From: Murray <Murray@murraylewis.myzen.co.uk>
Sent: 30 August 2022 13:16:42
To: Harry Chalk
Cc:
Subject: RE: EP/62/22/T, 1 Kerry Gardens

----- Original message -----
From: Harry Chalk <Harry.Chalk@arun.gov.uk>
Date: 30/08/2022 12:28 (GMT+00:00)
To: murray@murraylewis.myzen.co.uk
Subject: EP/62/22/T, 1 Kerry Gardens

This afternoon I received consultation from our Tree Officer regarding the above application. He is happy with the proposed works for T2 & T3 however, cannot support the works proposed to T1. We would like to invite you to agree to lesser works to T1 as described below.

1-1 1-2 1-3
 " " "
 Oak Teak Cedar

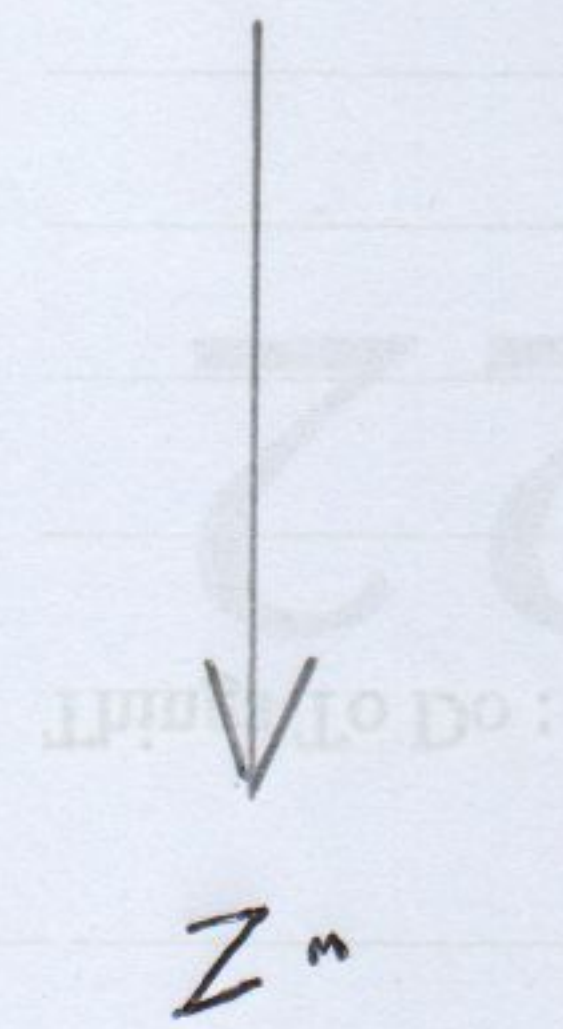
As it stands, I am unable to support this application. I would like the applicant to be invited to agree to a revised specification for lesser works on T1 (as described below) as part of the current application so as not to incur further delay. Such work would go some way to addressing their concerns whilst preventing a diminution of the tree's landscape and public amenity value:

- Remove crown reduction pruning entirely from the proposal.
- Amend crown lifting specification to: 'Remove/reduce small diameter branches (<50mm) as necessary to achieve a maximum 3metres overhead clearance on all aspects.'

Good Afternoon Harry,
I am in full agreement with the proposed amendment to T1.
Many thanks,
Murray
